**Re: Luddenham Resource Recovery Facility (SSD-10446) - Response to request for additional information**

This letter provides a response to the matters raised in the letter from Transport for NSW (TfNSW) (dated 25 May 2021) to the Department of Planning, Industry and Environment (DPIE) in relation to the Luddenham Advanced Resource Recovery Centre (SSD-10446) (the project). The matters raised in the TfNSW letter are provided in the grey text boxes with the responses following.

**ROADWORKS PLAN**  
SCALE 1:250

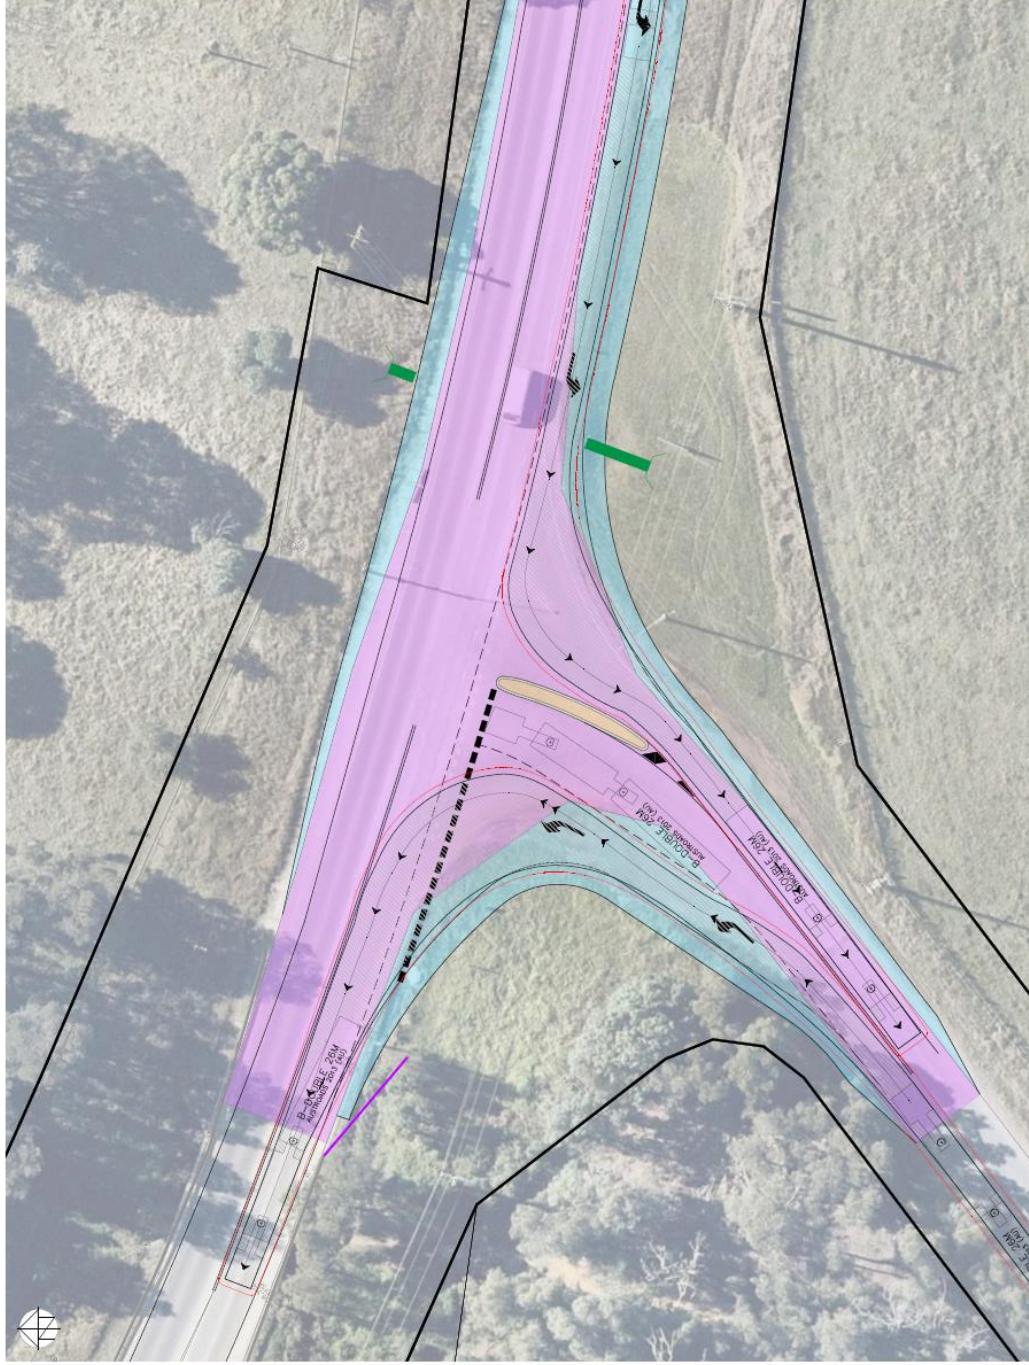
2. TfNSW understands that the proposed 90m long deceleration lane in the interim upgrade of Elizabeth Drive and Adams Road intersection is based on the requirements set out in Austroads for a design speed of 90 km/h with the deceleration rate of 3.5 m/s to a stop condition. As the left turn lane will mainly accommodate heavy vehicles, such as 26m B-Doubles, a deceleration rate of 2.5 m/s should be used with a turning speed of 20 km/h. This will require 120 metres including taper for the deceleration lane for the left turn movement.

As such, the concept design plan should be updated to address the above issue with showing the dimensions and submitted to TfNSW for review and approval.

3. A civil design plan of the interim intersection upgrade with relevant lane dimensions should also be submitted to TfNSW for review and approval.

4. It is also requested that a stormwater management plan for the proposed intersection upgrade should be provided to TfNSW for review and approval. A table drain system could be considered subject to the further design and approval by TfNSW.

The concept design for the proposed interim Elizabeth Drive/Adams Road intersection upgrade required to accommodate project related traffic is contained in Appendix C. This concept design has been updated to include a 120 m deceleration lane, relevant lane dimensions and stormwater management plan.
